1 December 2021

Our Reference: SYD16/00625/17  
DPIE Reference: SSD-9978934

**SSD-9978934: EXHIBITION OF ENVIRONMENTAL IMPACT STATEMENT (EIS)  
STAGE 2 COCKLE BAY WHARF MIXED USE DEVELOPMENT  
249 WHEAT ROAD, COCKLE BAY**

COCKLE BAY PARK  
 Swept Paths Assessment - CBP Drop-off  
 Wheat Road / Harbour Street

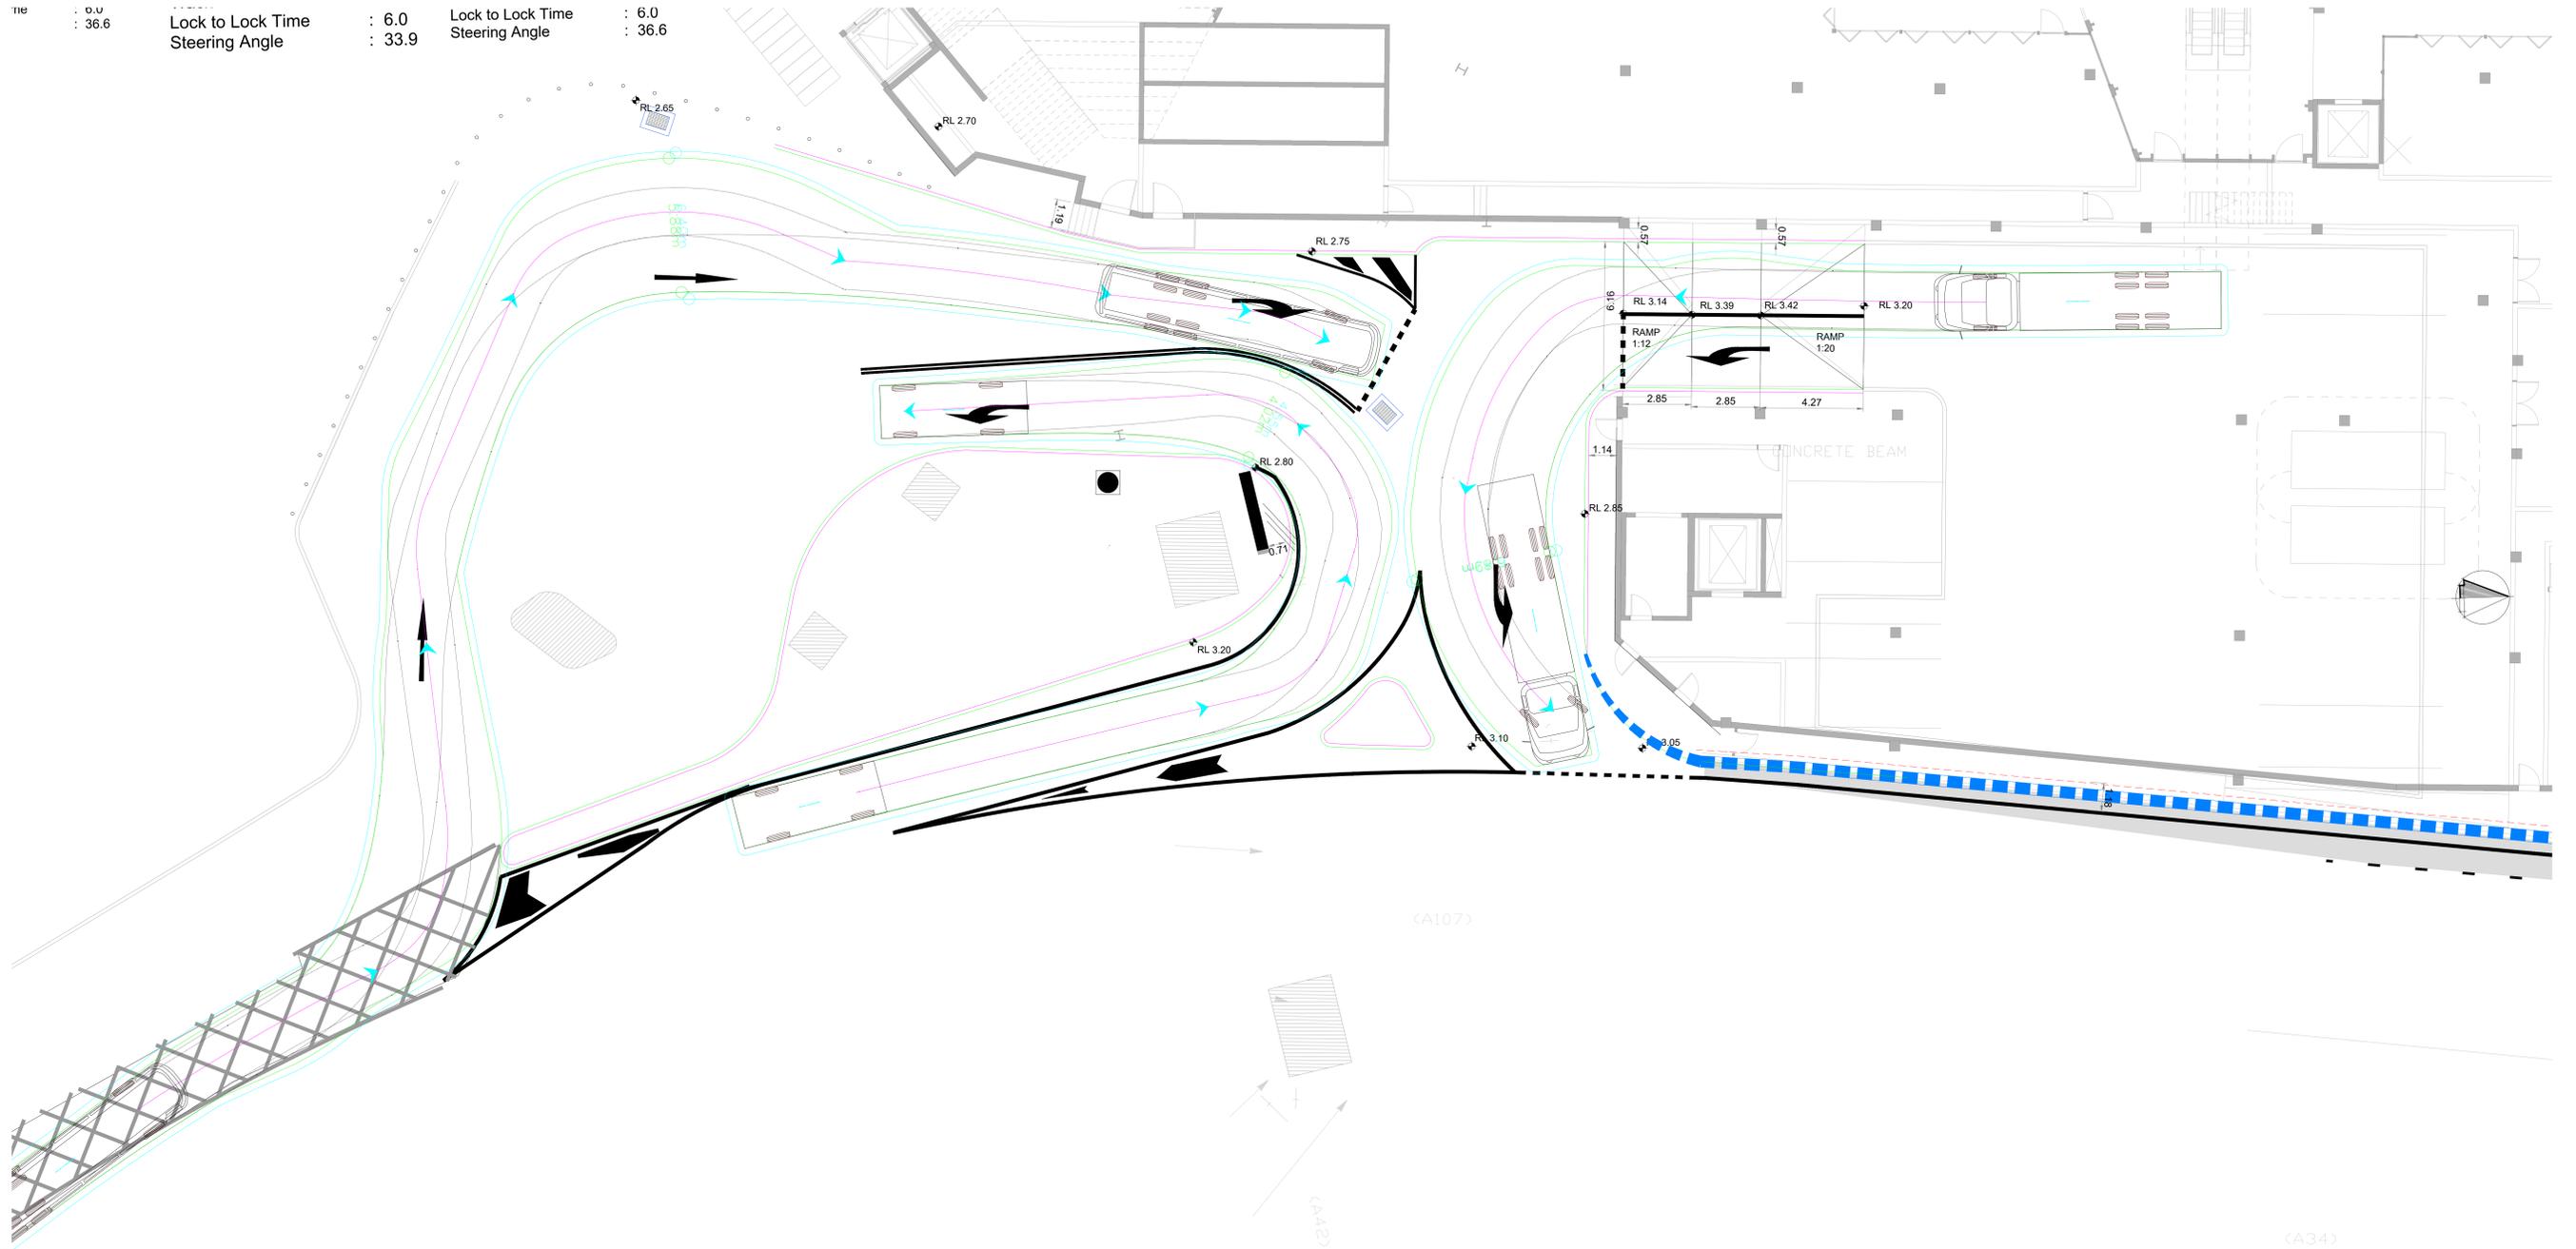
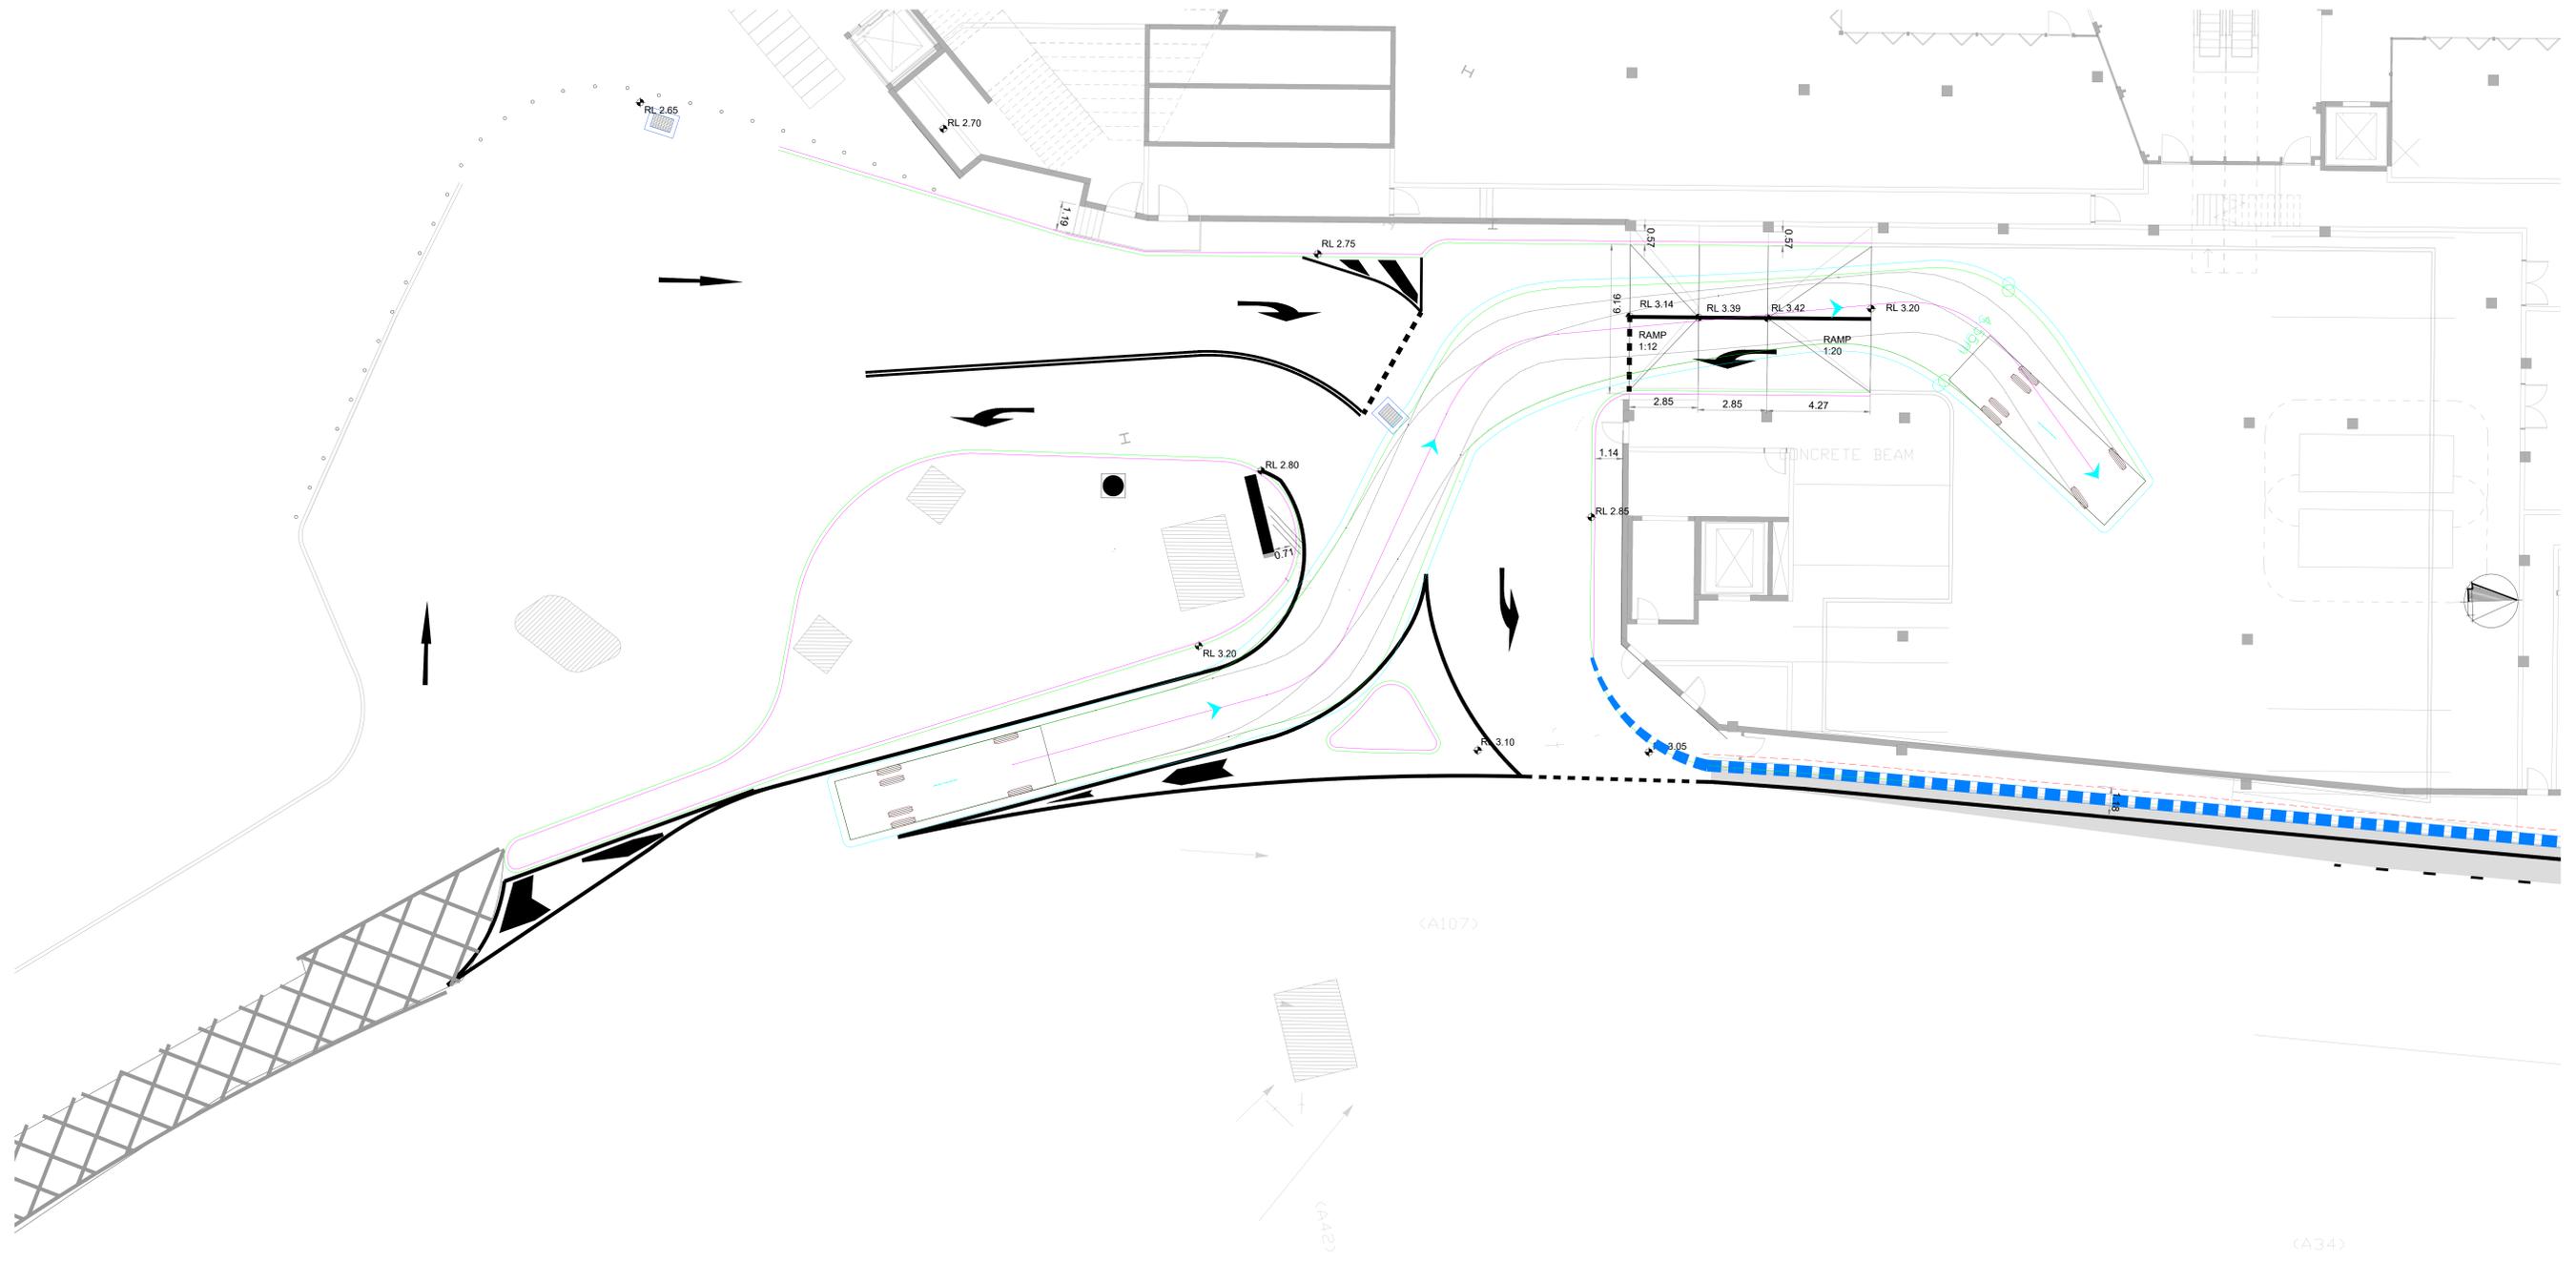
- Further it is not clear if the vehicle drop off, including ingress and egress, has been designed to accommodate stretched limousines which may serve the proposed development and the maximum coach size that the proposed Wheat Road configuration has been designed to as this is not clear from the swept path analysis provided in the Traffic Impact Assessment. It is also noted that the swept path analysis identifies that the coach design vehicle encroaches into the land outside of the proposed extent of the Wheat Road roadway.

- Details of the largest vehicle size that the proposed vehicle drop off, including ingress and egress and Wheat Road configuration have been designed should be provided (including swept paths and vehicle clearance heights), taking into consideration the use of coaches and stretched limousines within the vehicle drop off and Wheat Road configuration. Further, provision of a swept path analysis identifying that the proposed Wheat Road configuration adequately accommodates the coach design vehicle should also be provided.
